**WEST SUSSEX COUNTY COUNCIL
STRATEGIC PLANNING CONSULTATION**

SUBJECT: WA/63/16/PL - Demolition of 3 No. existing agricultural buildings & erection of new agricultural building & farm workshop/office.

Fairmead Farm, Binstead Lane, Arundel, West Sussex, BN18 0LQ

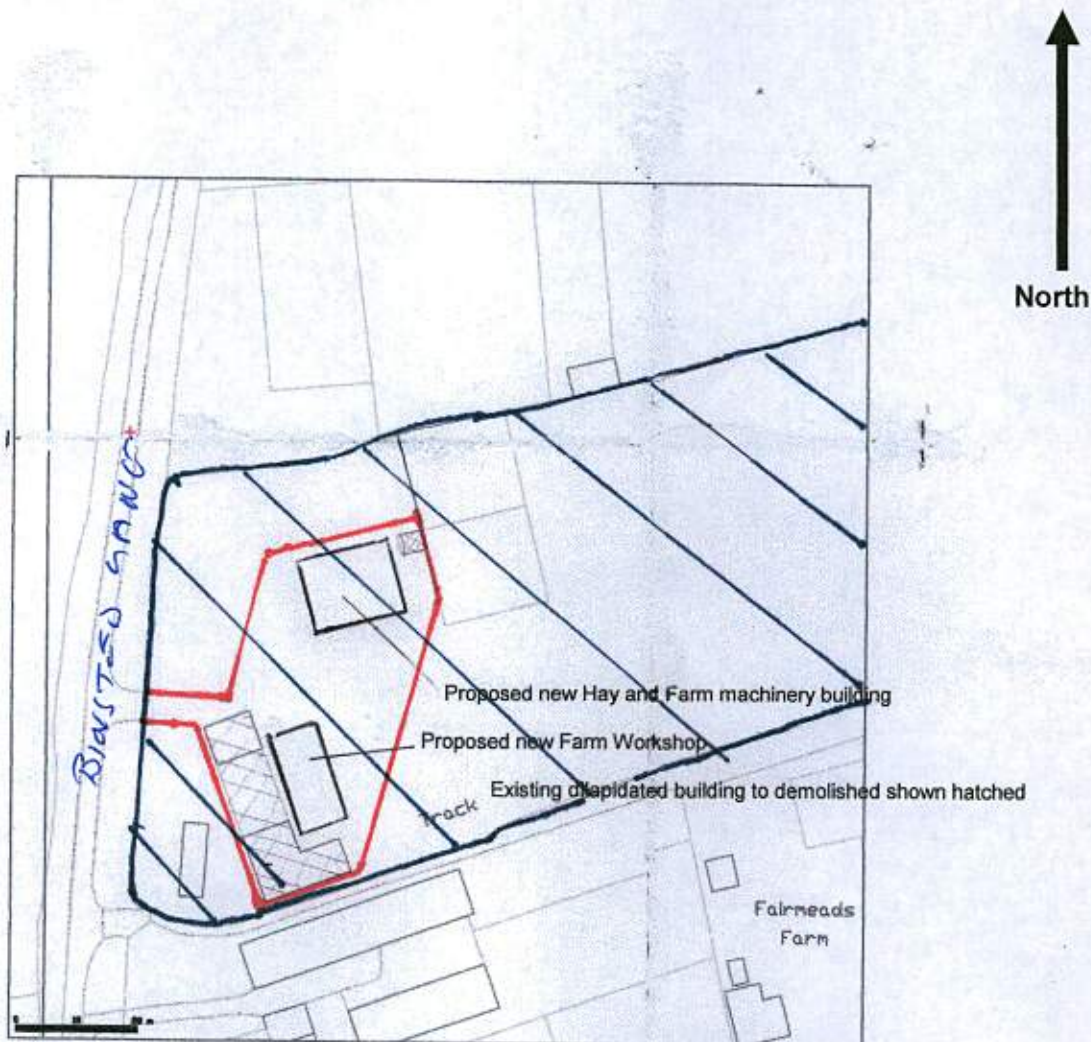
Access to the site is achieved via an existing point of access from Binstead Lane. Binstead Lane is unclassified Lane subject to the national speed limit. Though given the nature of Binstead Lane namely its alignment and width it is extremely unlikely that vehicles will be approaching the site access point at this speed.

The applicant would be requested to demonstrate the maximum achievable levels of visibility at this access point in line with the principles and guidance set out within Manual for Streets. This is to allow the Local Highways Authority to assess if the access point is adequate in terms of visibility to accommodate the increased vehicular activity anticipated.

From inspection of the existing vehicle crossover serving the site improvements could be made to the construction of the crossover with the access point being upgraded to a heavy duty specification.

While the existing access crossover is wide and splayed the applicant should demonstrate that the access point's geometry is adequate to meet the needs of vehicles intended to use the access point. This can be done by way of swept path tracking plans.
